**Re: Oxbow Development / Coors Pavilion (St. Josephs Dr. / Coors Blvd.)**

I will be resubmitting the Traffic Impact Study for the Referenced Oxbow Development / Coors Pavilion project in the future to address both the City's comments as well as the NM DOT comments. For the time being, I will address your comments to the best of my ability in this letter. Your comments were transmitted to me on March 8, 2022 in letter form attached to an e-mail. Below is a summary of your comments and my responses:

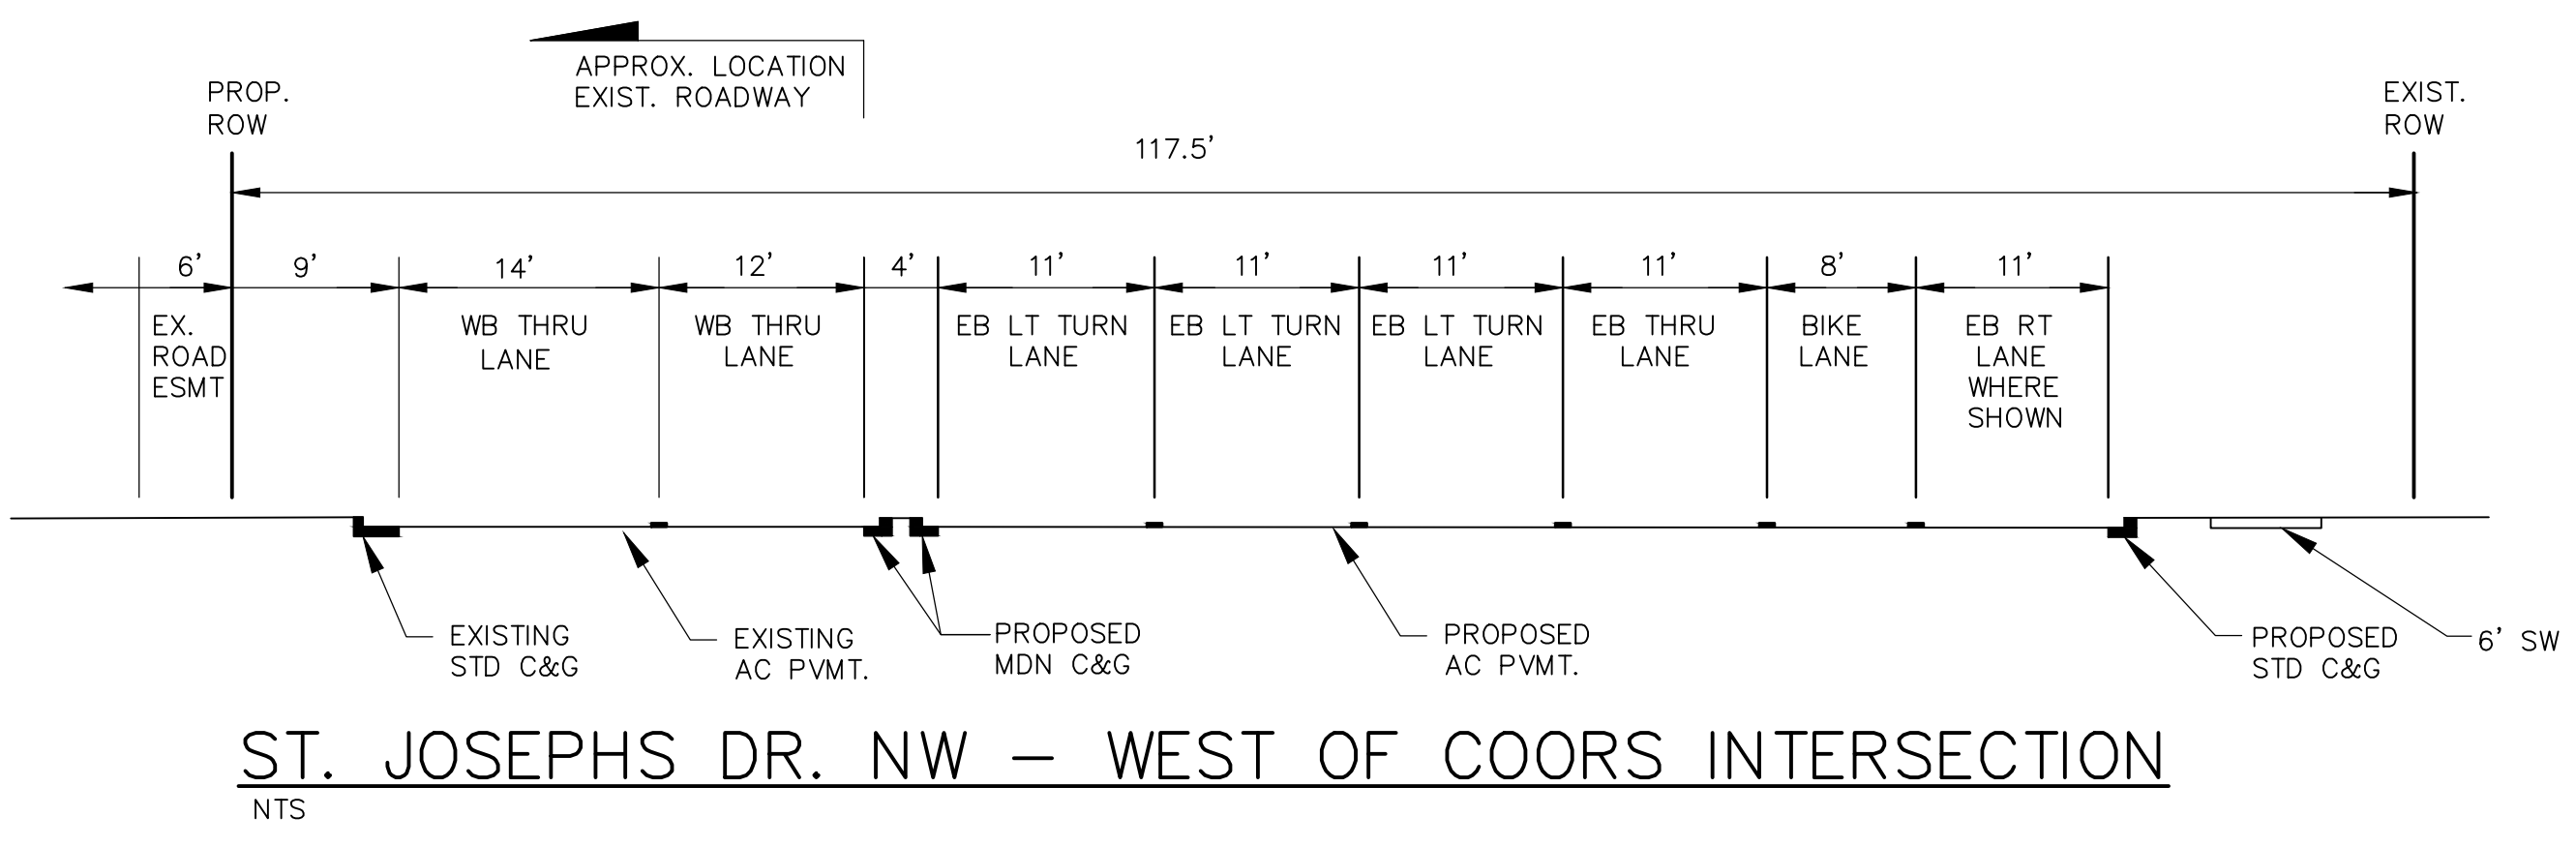
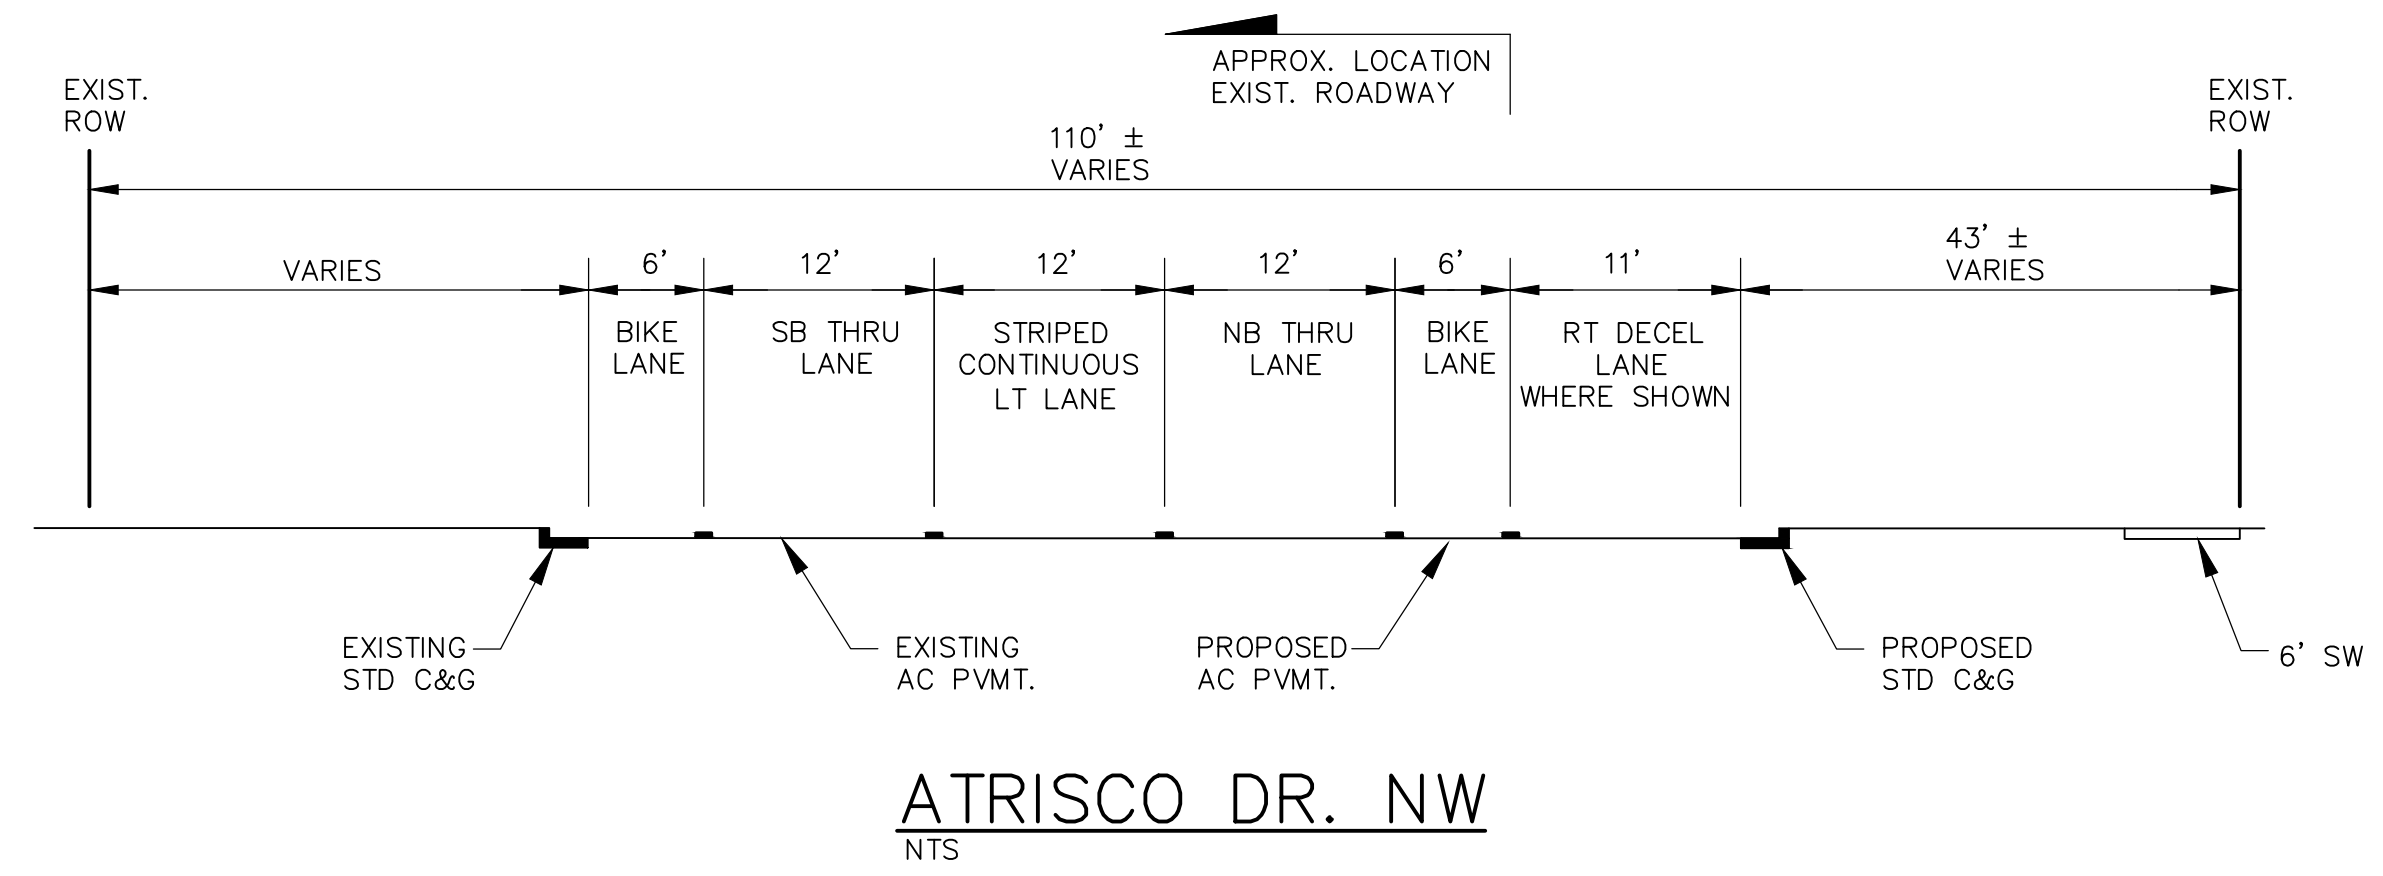
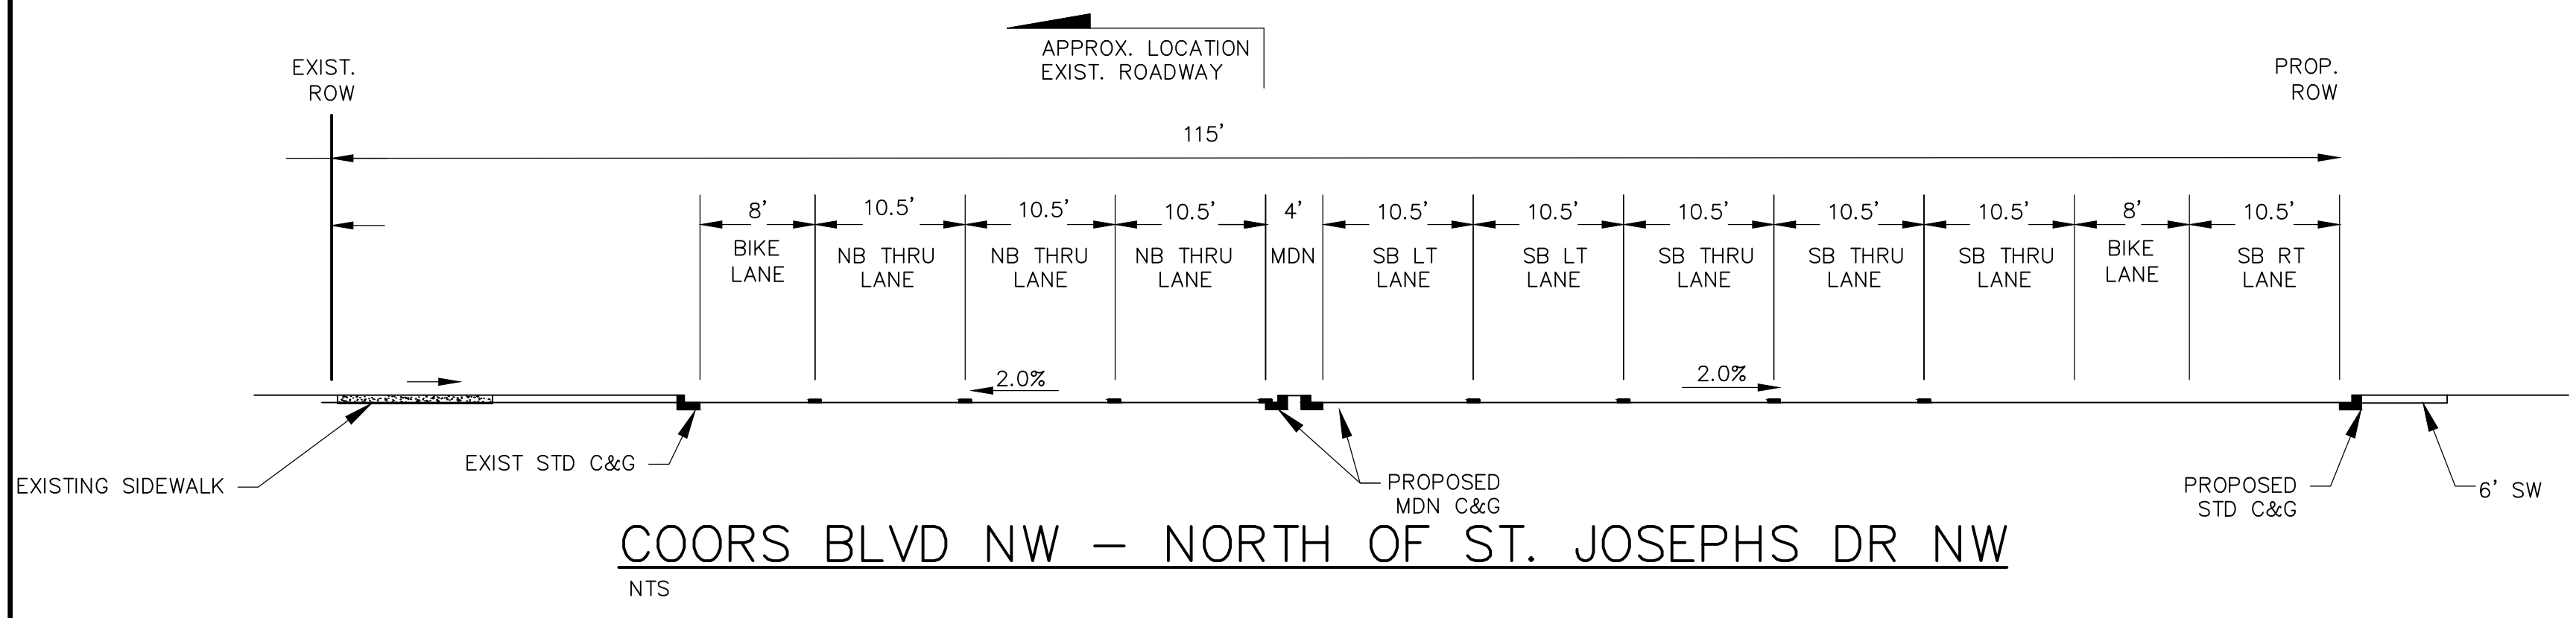
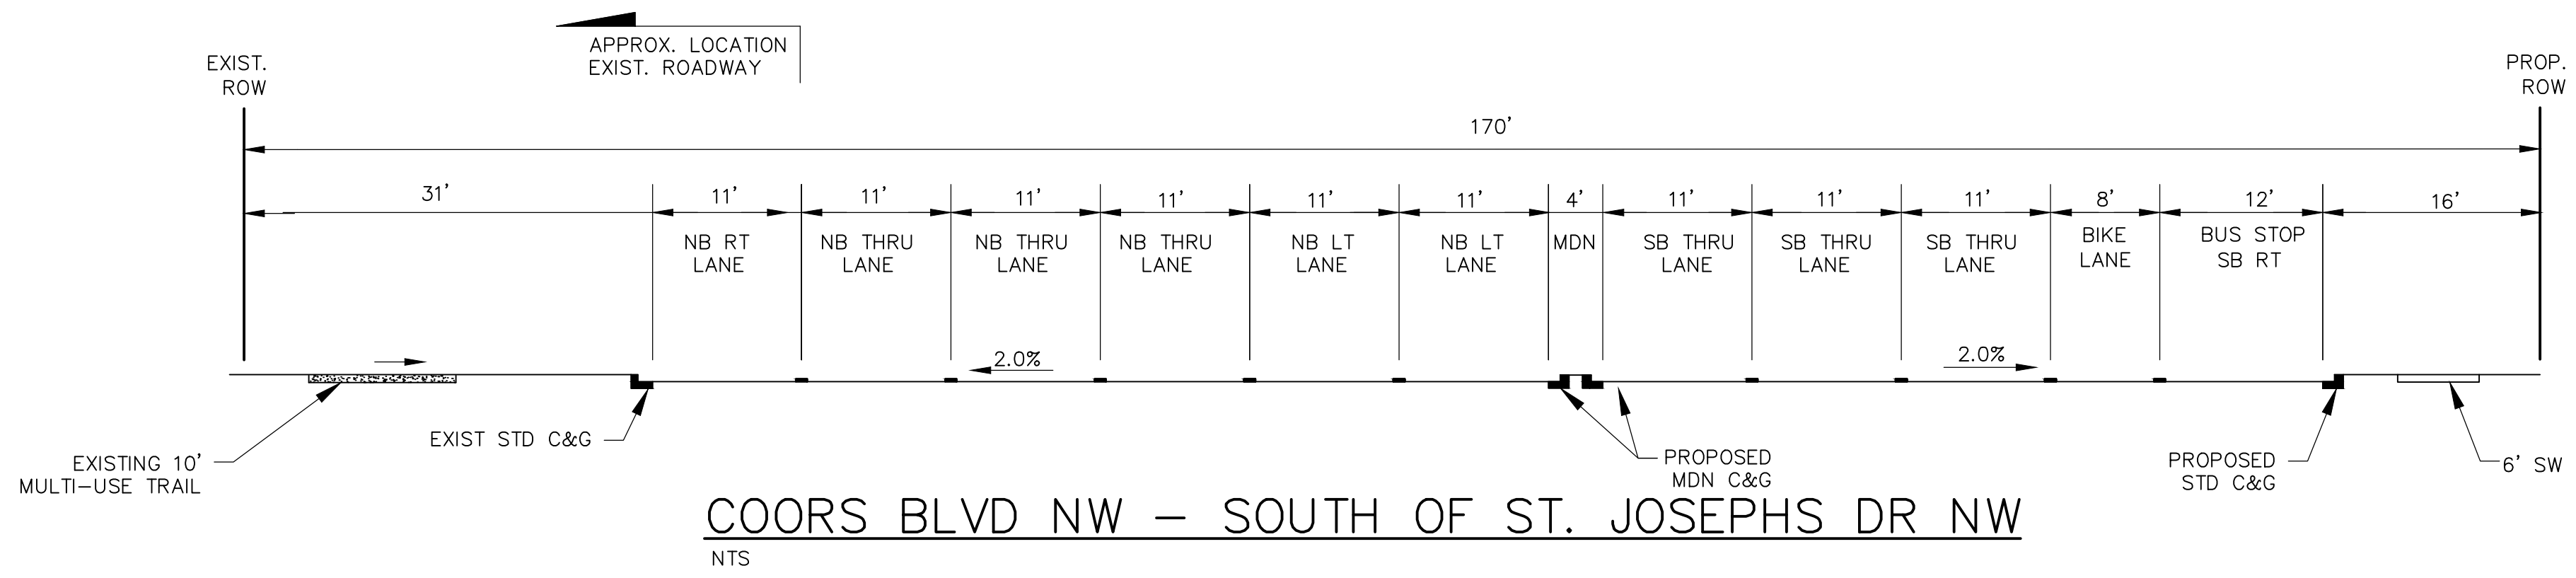
**Comment:** Add eastbound bicycle lane with buffer to the cross-section.

**Comment:** Provide a conceptual footprint of the main entrance to show that it will fit in the existing ROW. Add the eastbound bicycle lane with buffer.

**Response:** We acknowledge that the developer will be required to construct St. Josephs Dr. from Atrisco Dr. to Coors Blvd. to meet all of the City of Albuquerque's Design Standards in the Development Process Manual including bicycle lanes.

**Response:** The attached graphical conceptual roadway plan demonstrates that the main entrance will fit in existing ROW and an eastbound bicycle lane is shown.
